WEST SUSSEX COUNTY COUNCIL CONSULTATION

TO:	Arun District Council FAO: Harry Chalk
FROM:	WSCC – Highways Authority
DATE:	9 March 2026
LOCATION:	Braymead 37 Nyewood Lane Bognor Regis PO21 2SJ
SUBJECT:	BR/18/26/PL Change of use from 10-bedroom guest house to 8-bedroom House in Multiple Occupation, with associated alterations.
DATE OF SITE VISIT:	n/a
RECOMMENDATION:	Advice

1 Proposed Site Plan
1 : 100

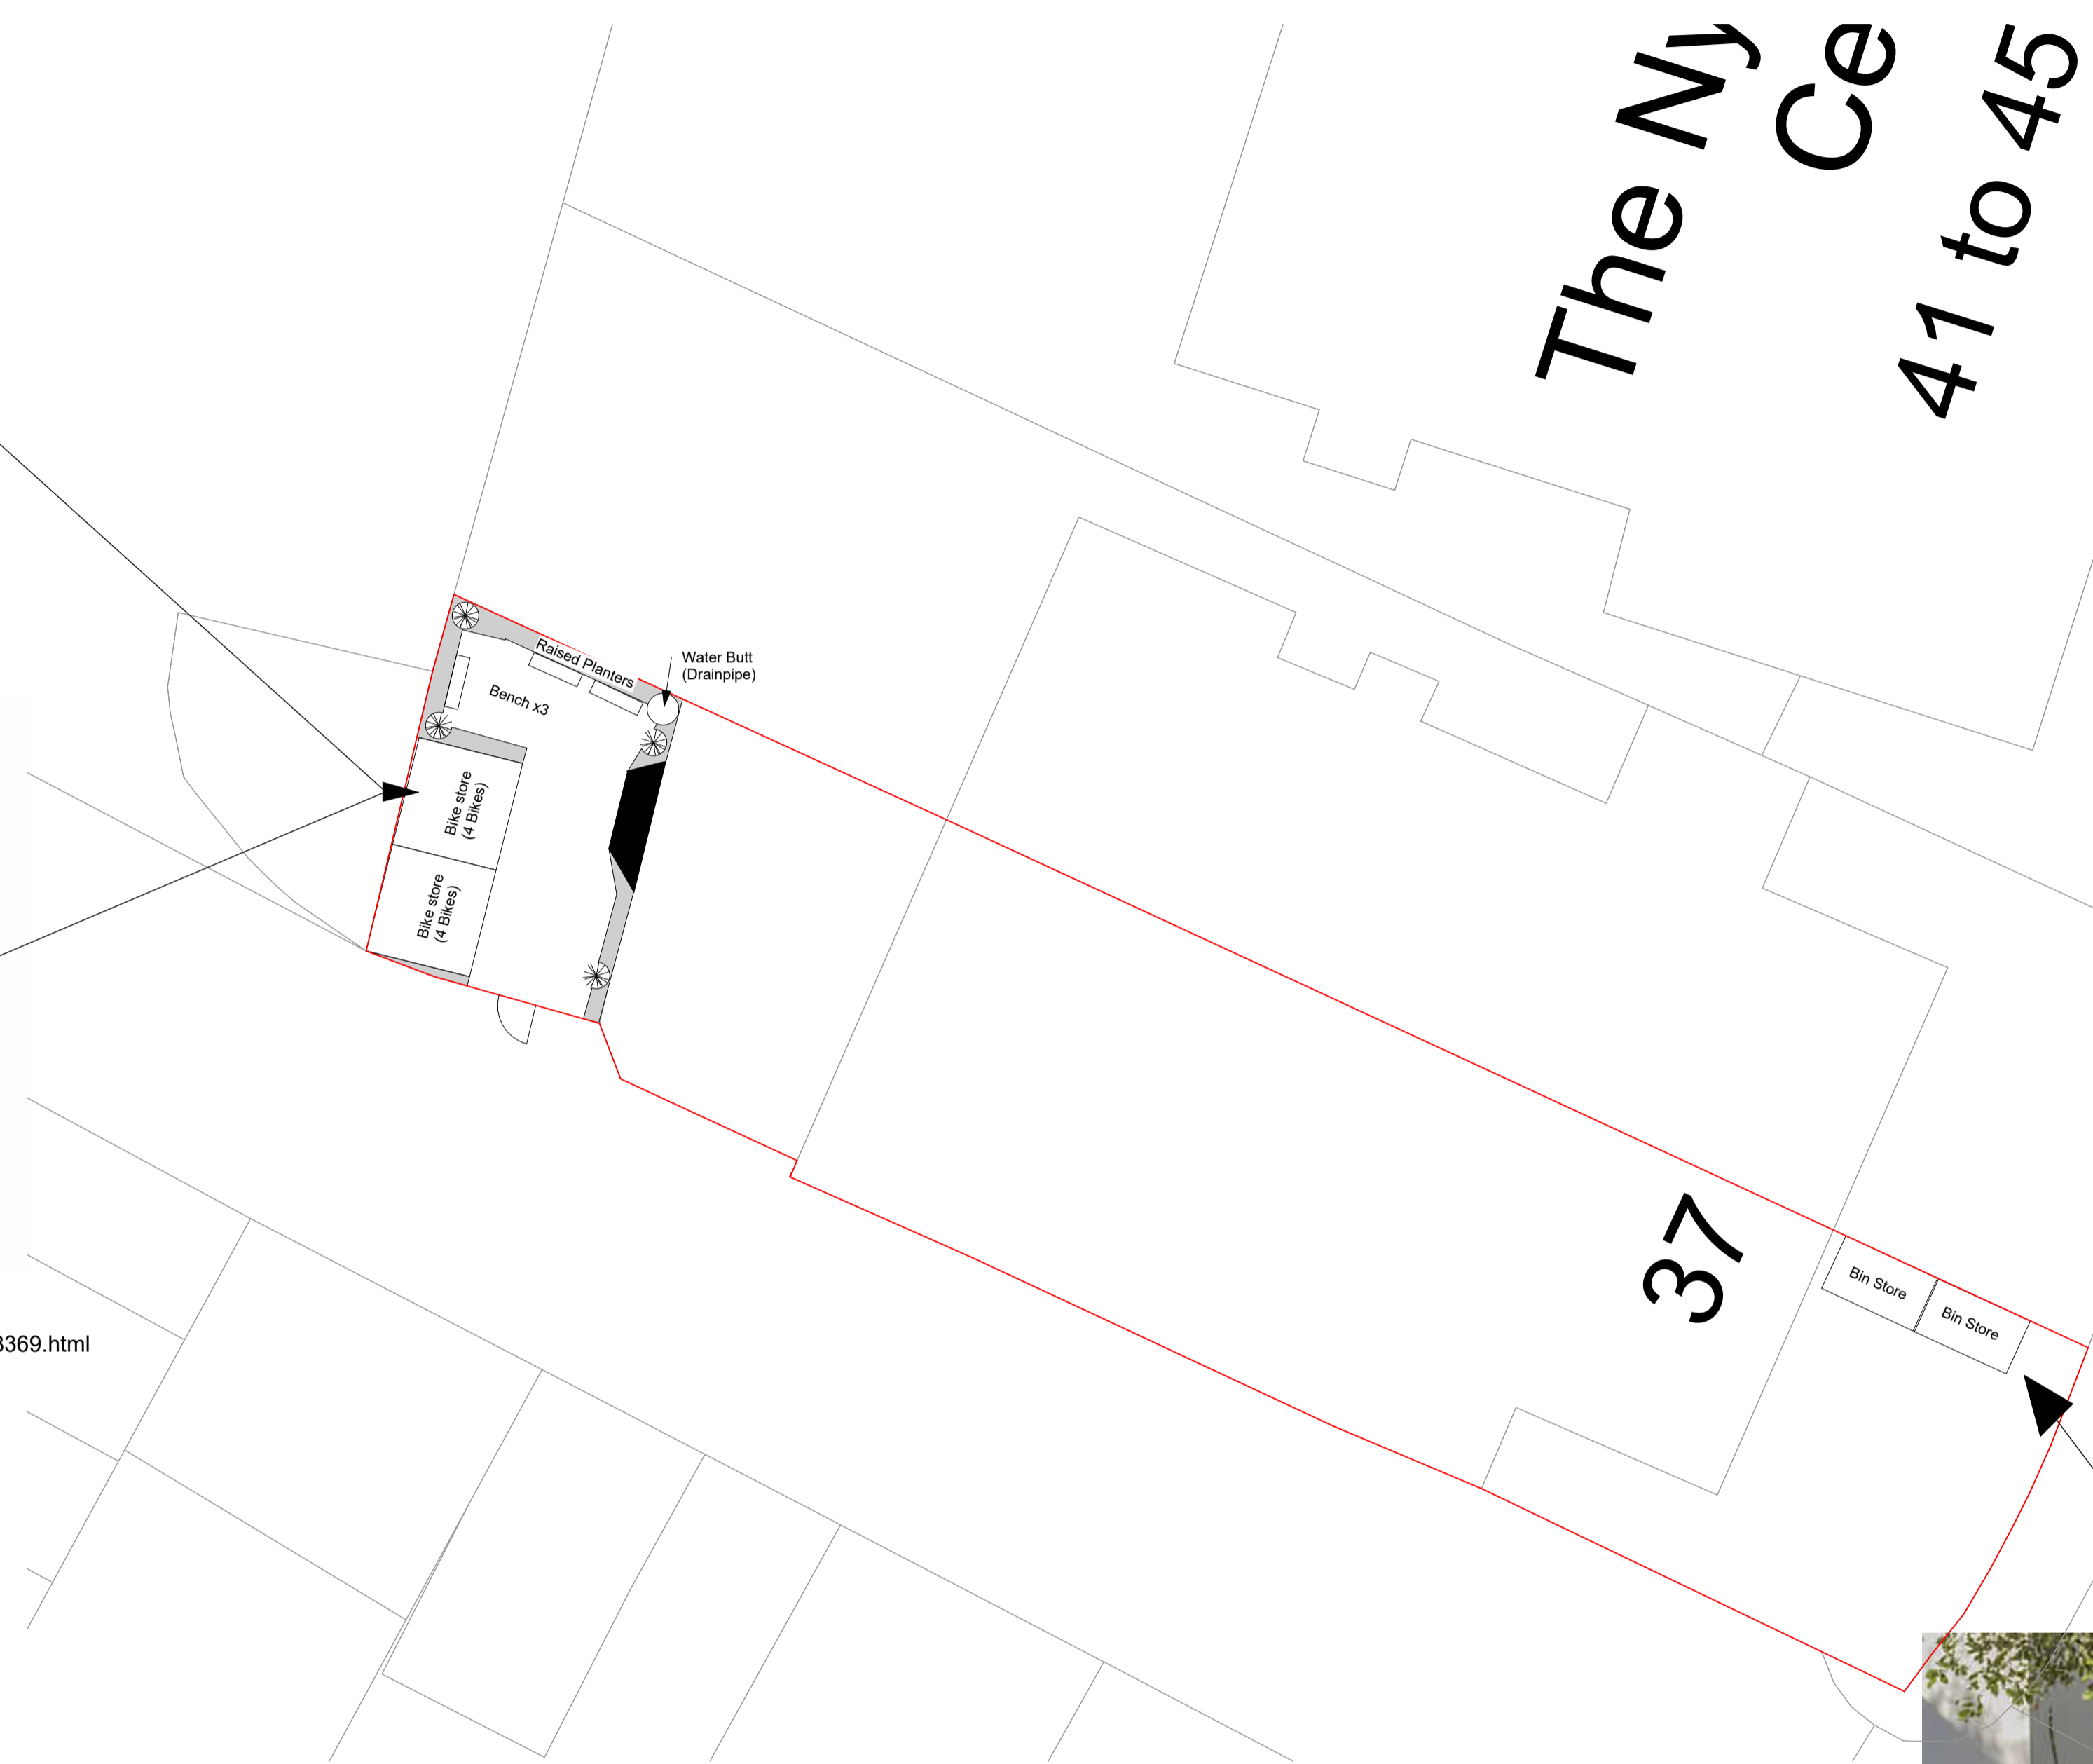
The application form outlines that there are no parking spaces serving the site although the planning statement and local mapping shows a garage to the rear of the property which is to be removed for the purposes of this application. There are no known dimensions of the garage and therefore it is unclear whether this could in its current format be used as a parking provision.

Cycle parking has been proposed at the rear of the development; to replace the garage building. A provision of a single space per room is allocated and would be considered suitable to satisfy the likely demand. The site is located within an area where cycling is a viable alternative to the use of a car for a number of journeys and it is advised that cycle parking is sealed via planning condition alongside any permission of this application.

No part of the development shall be first occupied until covered and secure cycle parking spaces have been provided in accordance with plans and details to be submitted to and approved by the Local Planning Authority.
